# CITY OF ALBUQUERQUE

**Re: The Estates at Glendale Unit 1**  
**Grading and Drainage Plan**  
**Engineer's Stamp dated 3-13-12 (B19/D027)**

Based upon the information provided in your submittal received 03/02/12, the above referenced plan can not be approved for Preliminary Plat action by the DRB until the following comments are addressed.

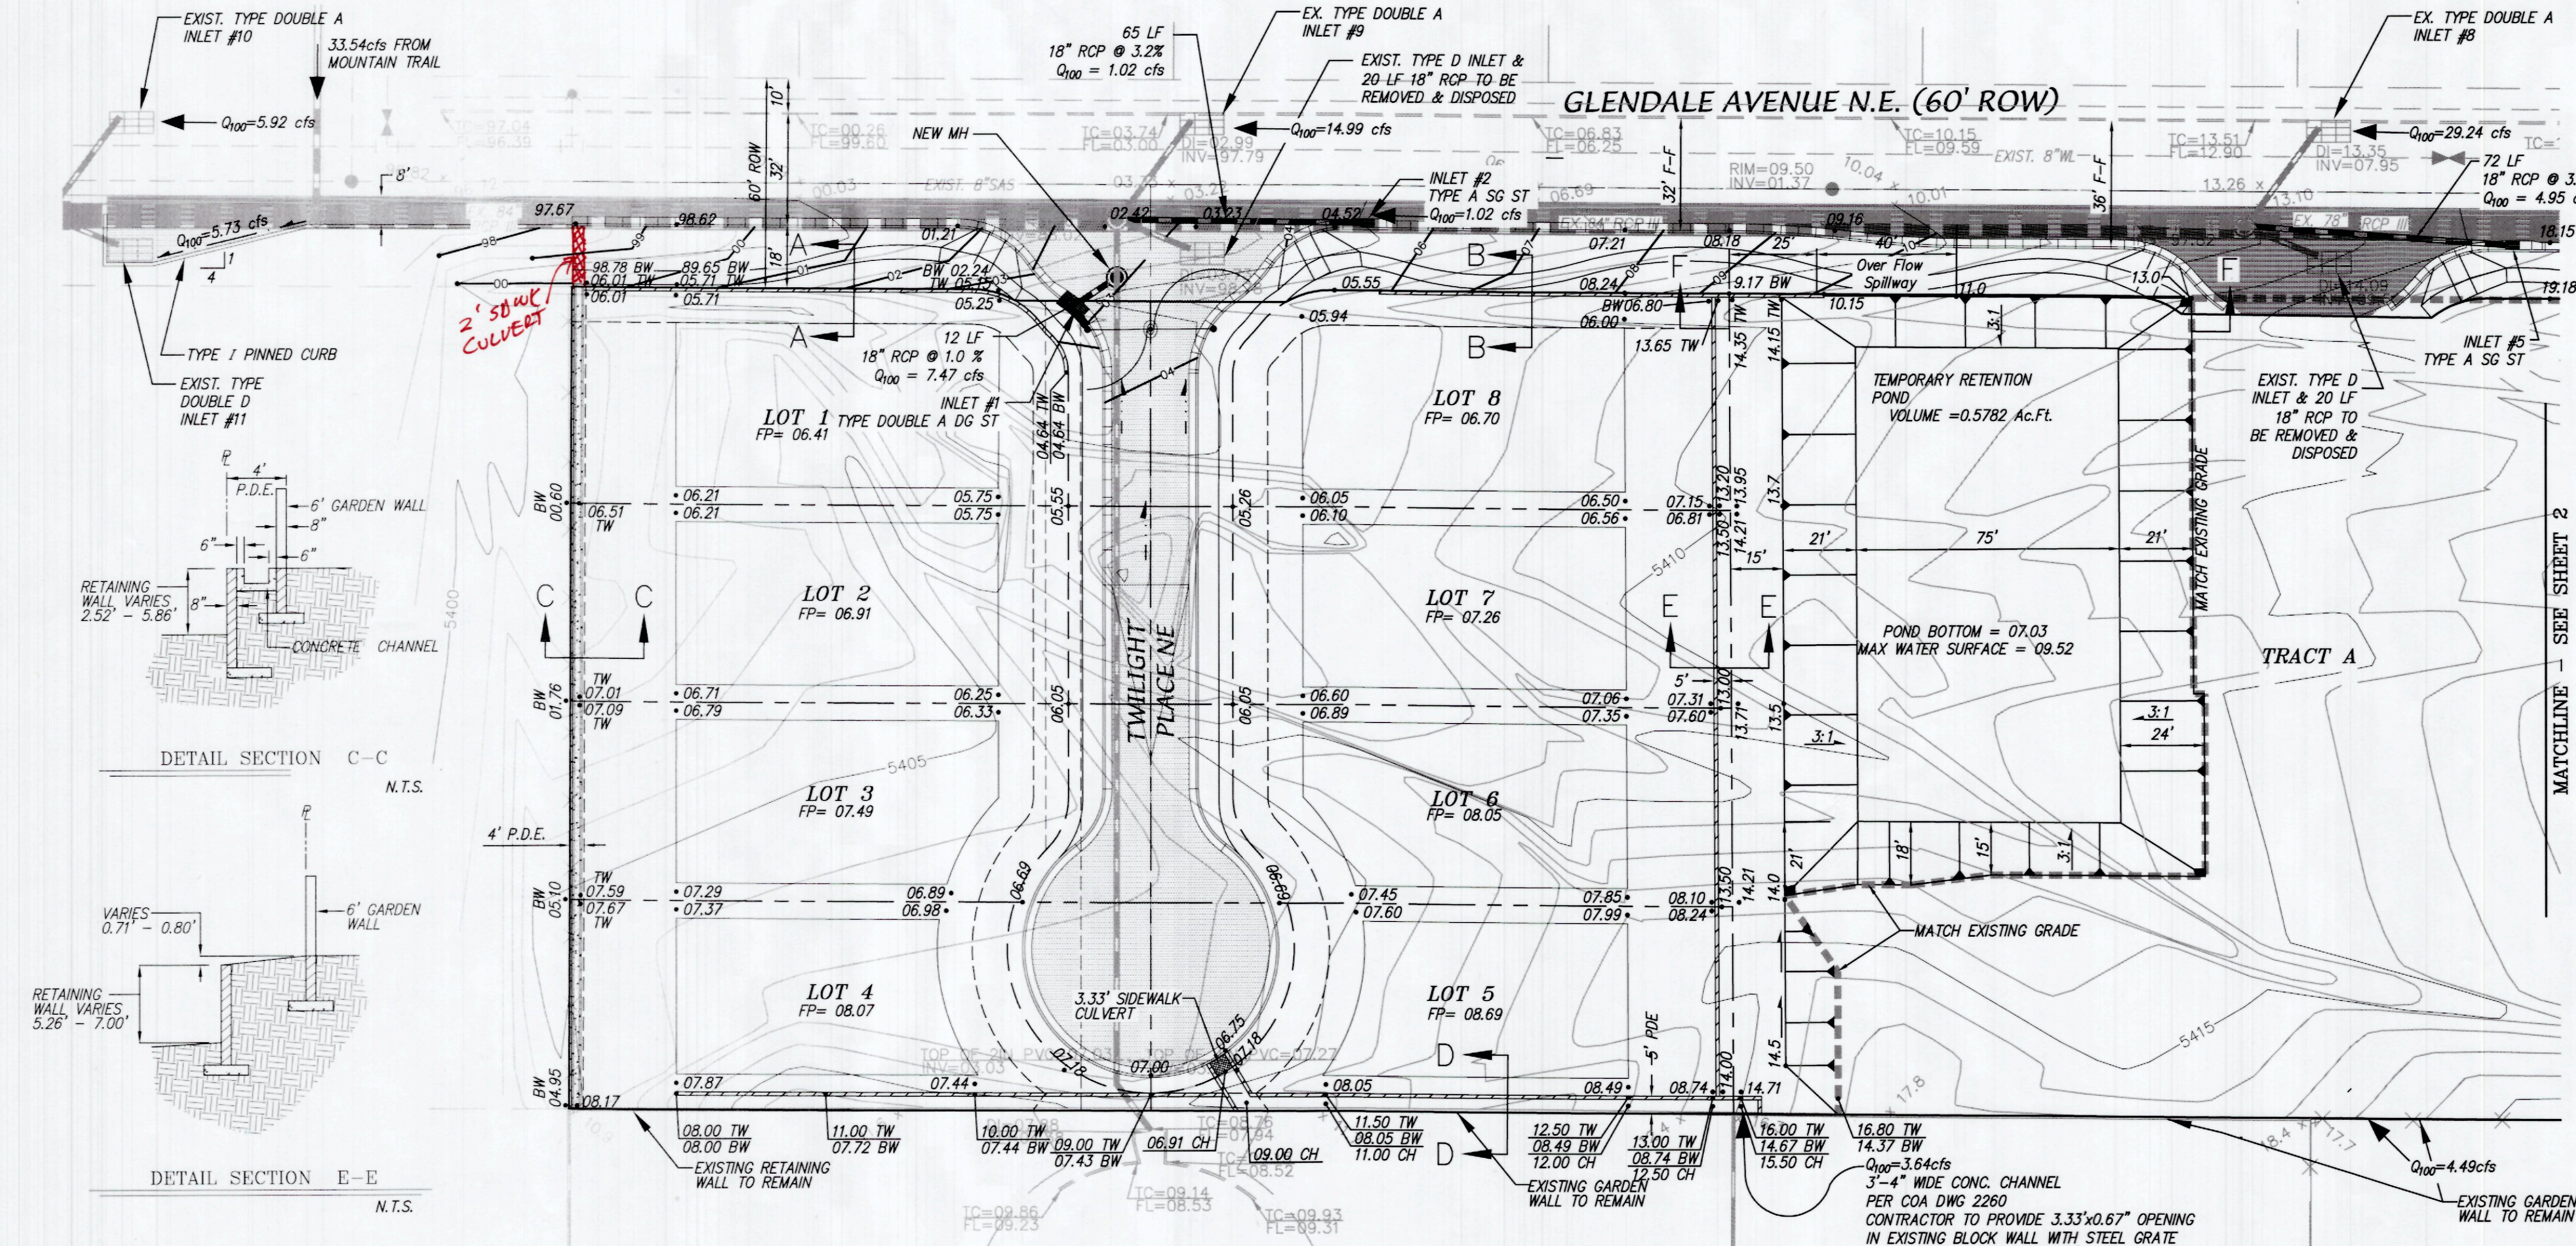
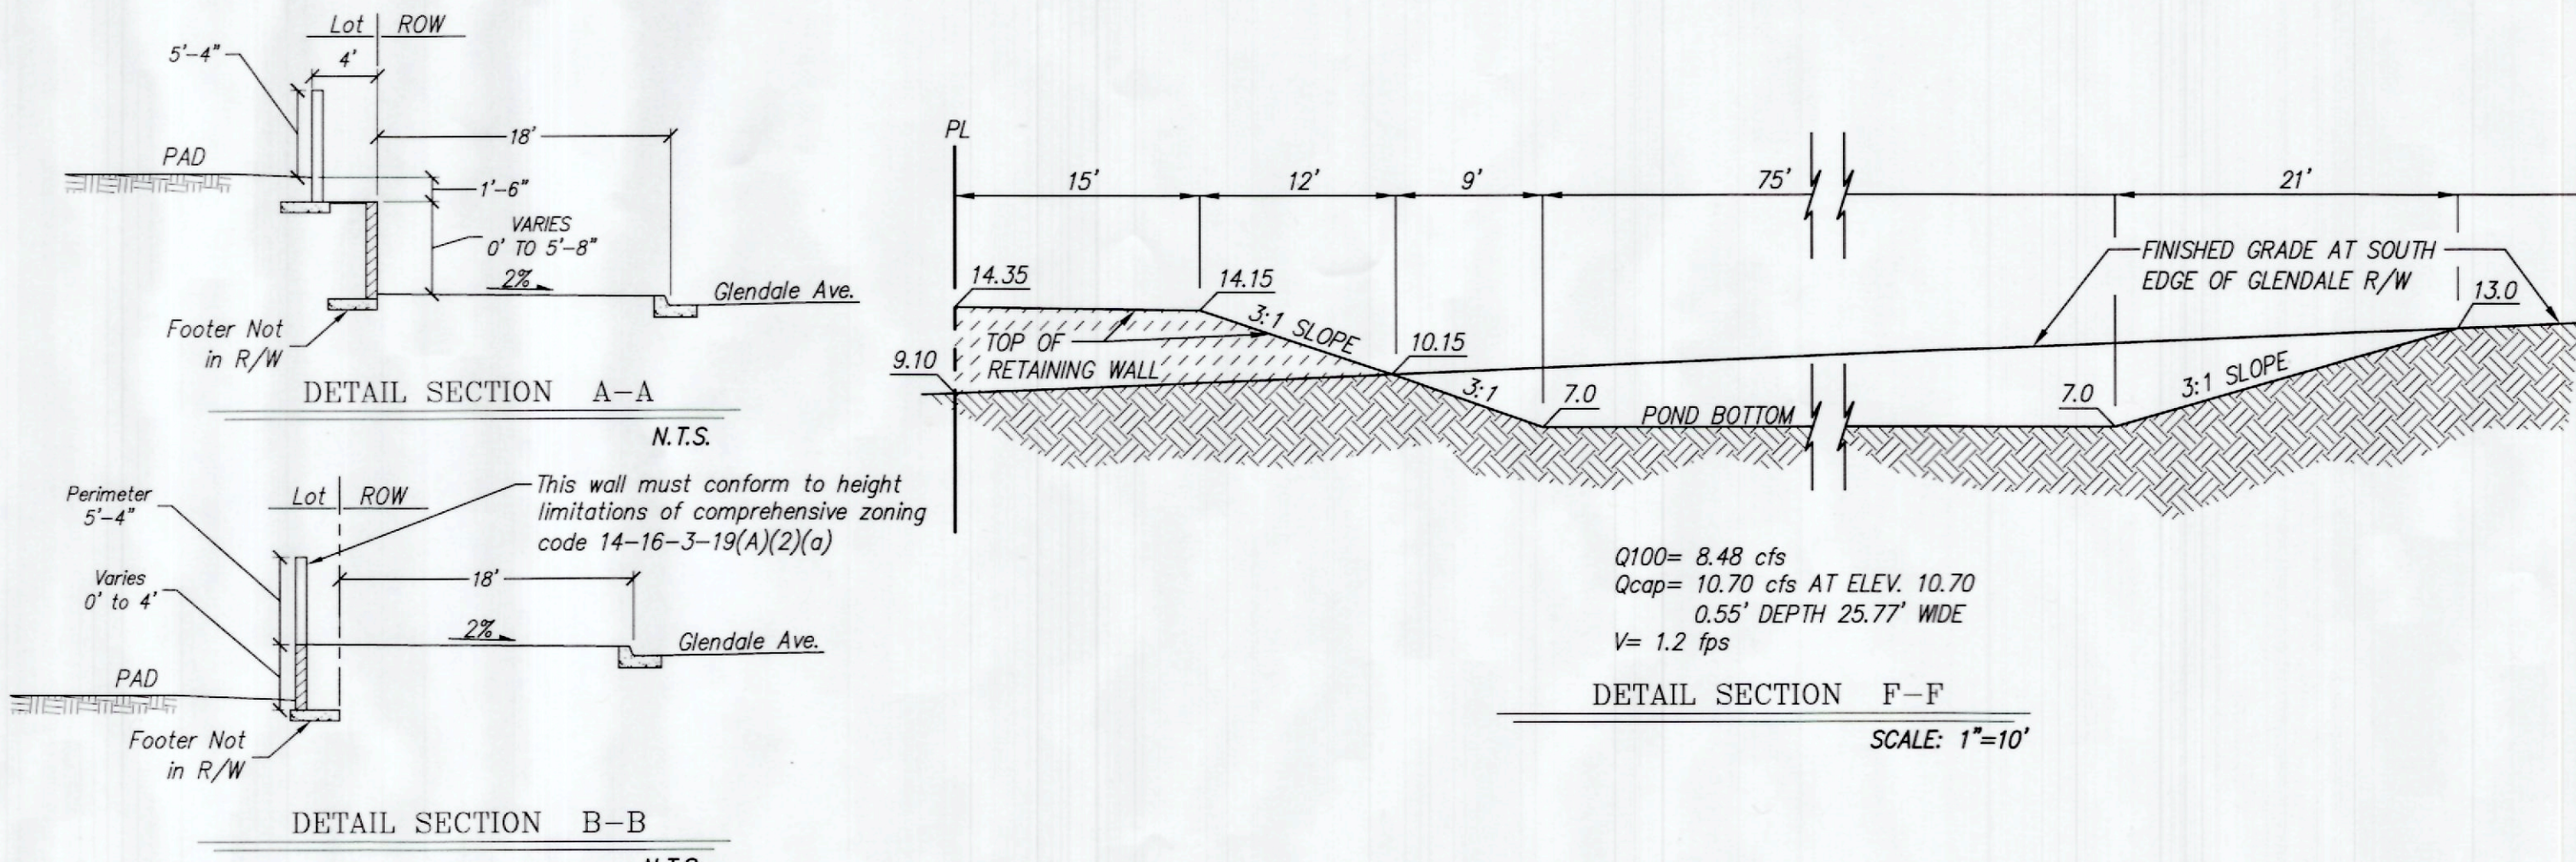
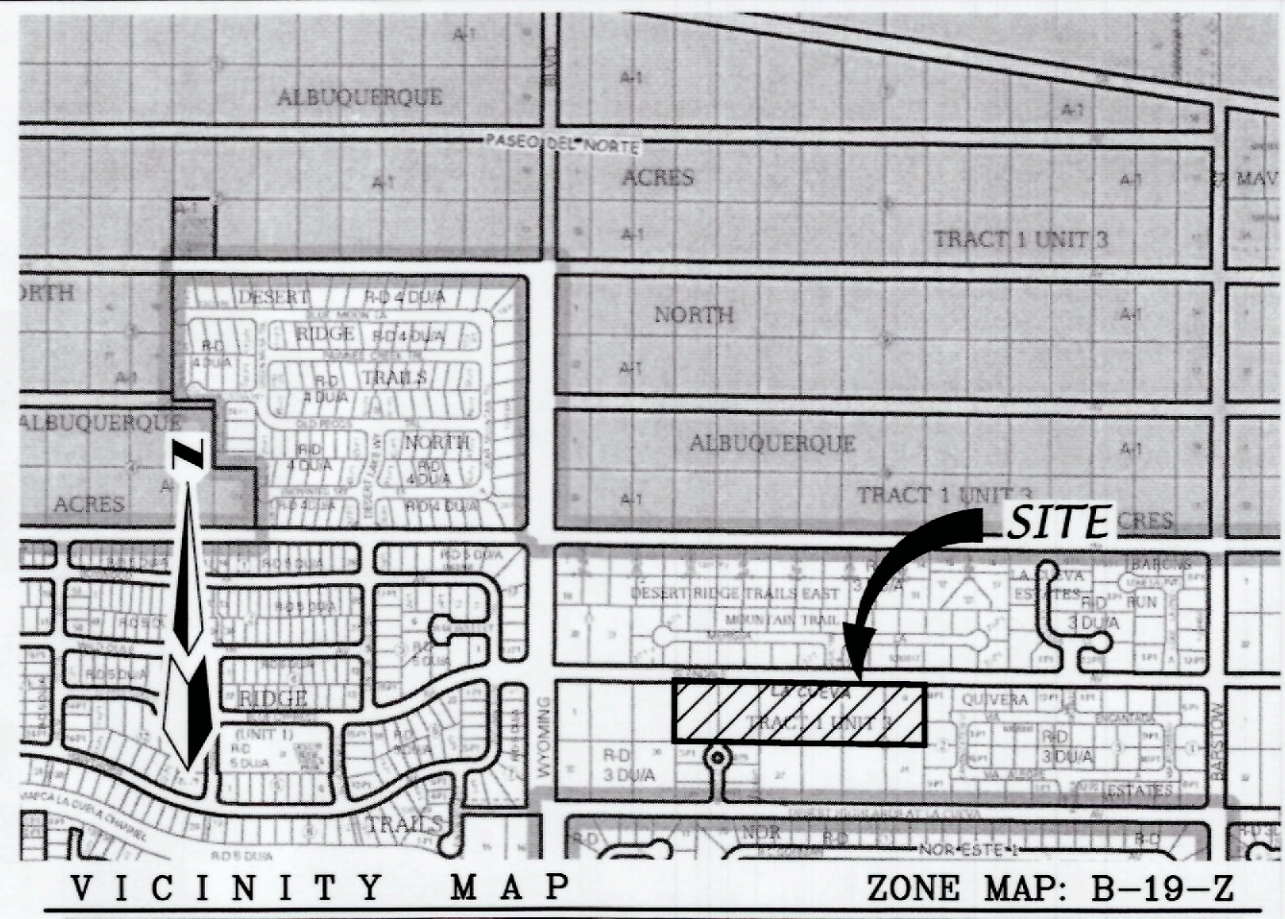
- The SD pipe in Glendale Ave. and in Twilight Place is too close to the gutter, which would cause extraordinary hardship to the city, if the pipe needed repair or replacement. Please adjust accordingly.

- The original plan displayed two walls to the west of phase 1. This seems to be the proper design for this location. The height of a single wall goes above the allowable height.

- The channel to the south of the sub-division does not work well with the sidewalk and the placement of a sidewalk culvert. The channel is too steep at this location and would not match the 2% slope of a sidewalk. In this same location a slope of 1:1 is shown along with the channel. It may be better to lower the elevation at the east end of the channel to meet the slope at the west end where the sidewalk culvert will be placed.

- What are the grades at the top of pond? How and in which direction is the spillway allowing emergency overflows to exit?
- Is a man hole located at the south end of Twilight Place? Will the man hole be moved so that it is not in the sidewalk?
